# CITY OF ALBUQUERQUE

June 27, 2017

RE: **10512 Redbud Residence**  
**10512 Redbud NW**  
**Grading Plan**  
**Engineer's Stamp Date 6/20/17 (File: A12D027)**

Based upon the information provided in your submittal received 6/21/17, the Grading Plan cannot be approved for Building Permit until the following are addressed:

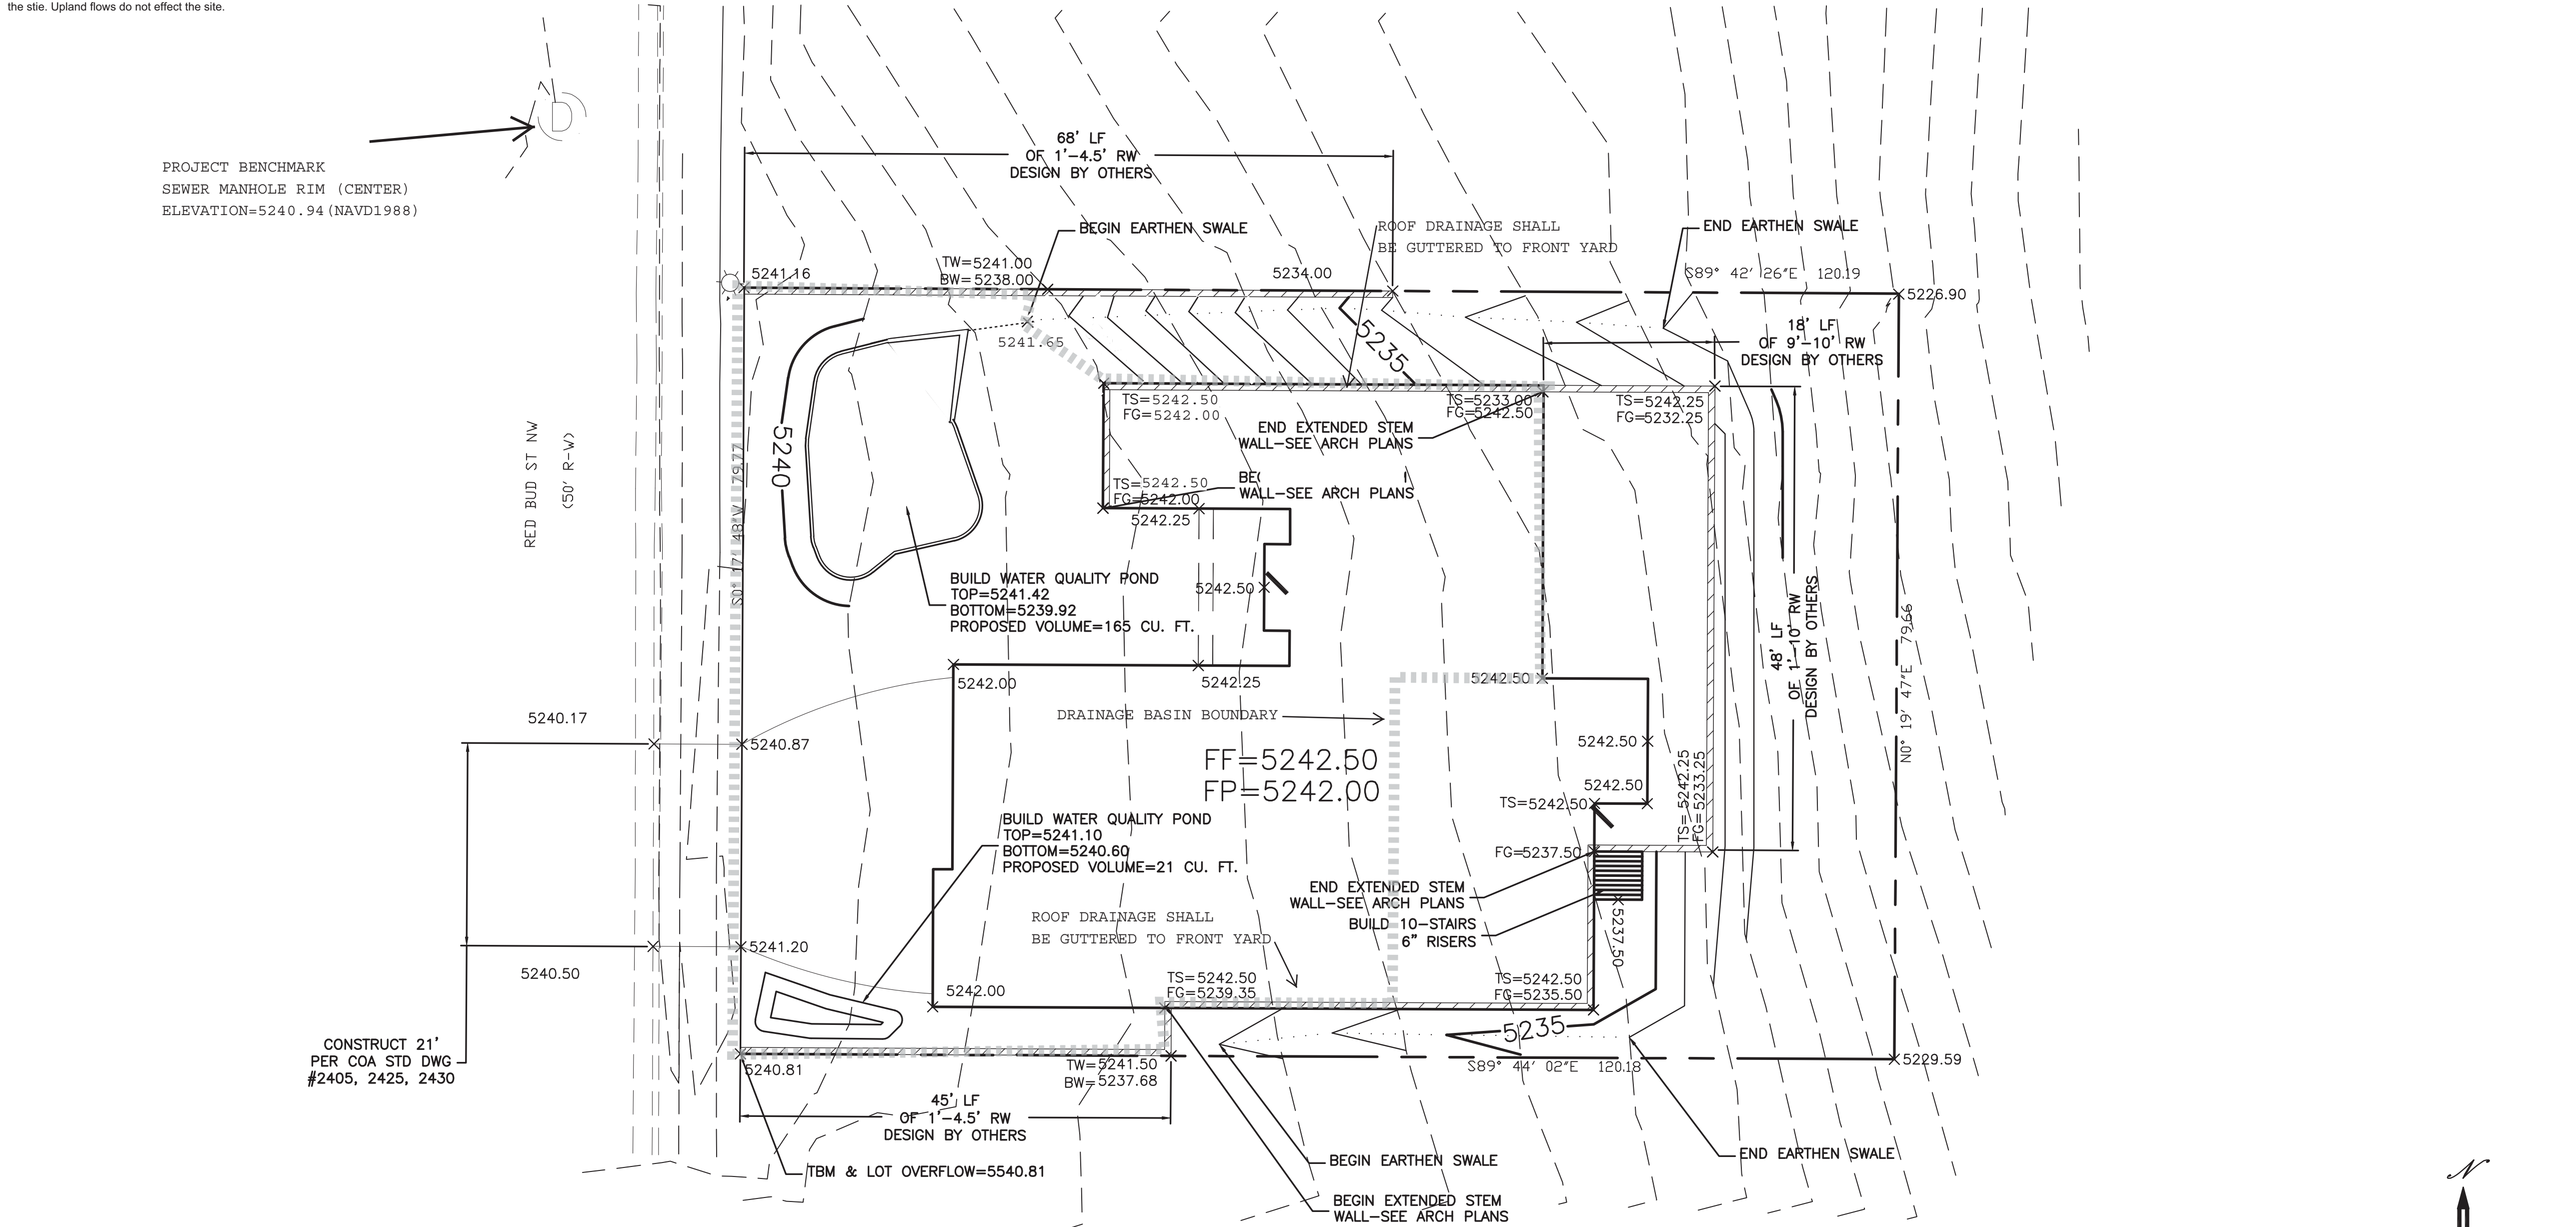
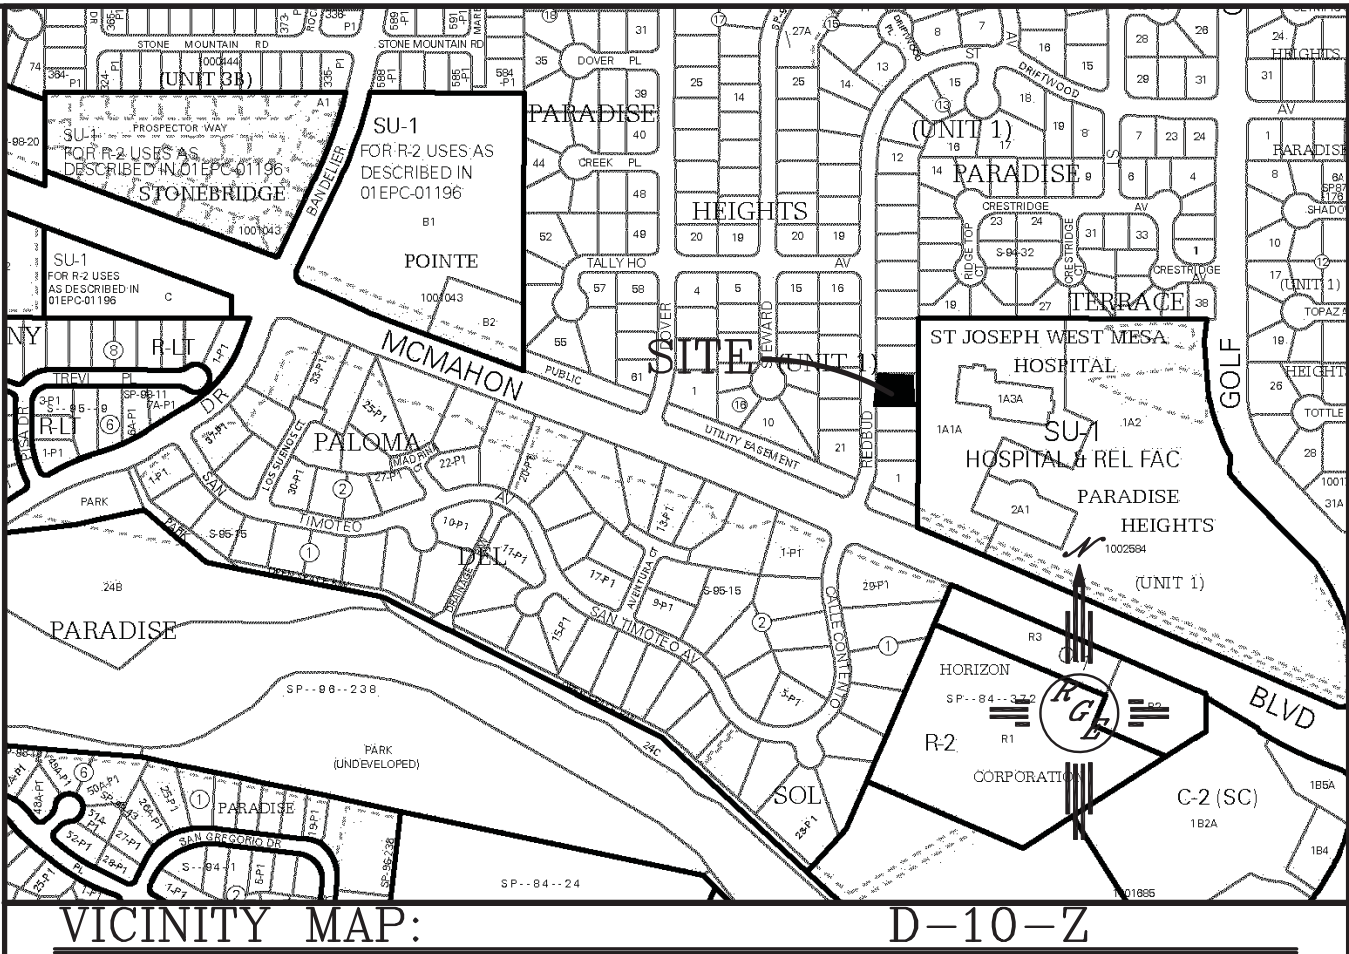
1. Show and calculate the sub-basin divide between the front of lot and back of lot. From the grading plan, it appears about half the site will drain west to the ROW and half to the east to an adjoining lot.
2. For properties that historically drain to an adjoining lot, where the adjoining lot has an outfall, the adjoining lot should not see a change in peak flow. It appears the entire lot historically drained to the adjoining lot, therefore the proposed discharge to the back of this lot cannot exceed 0.38 cfs. This must be demonstrated on the plan.
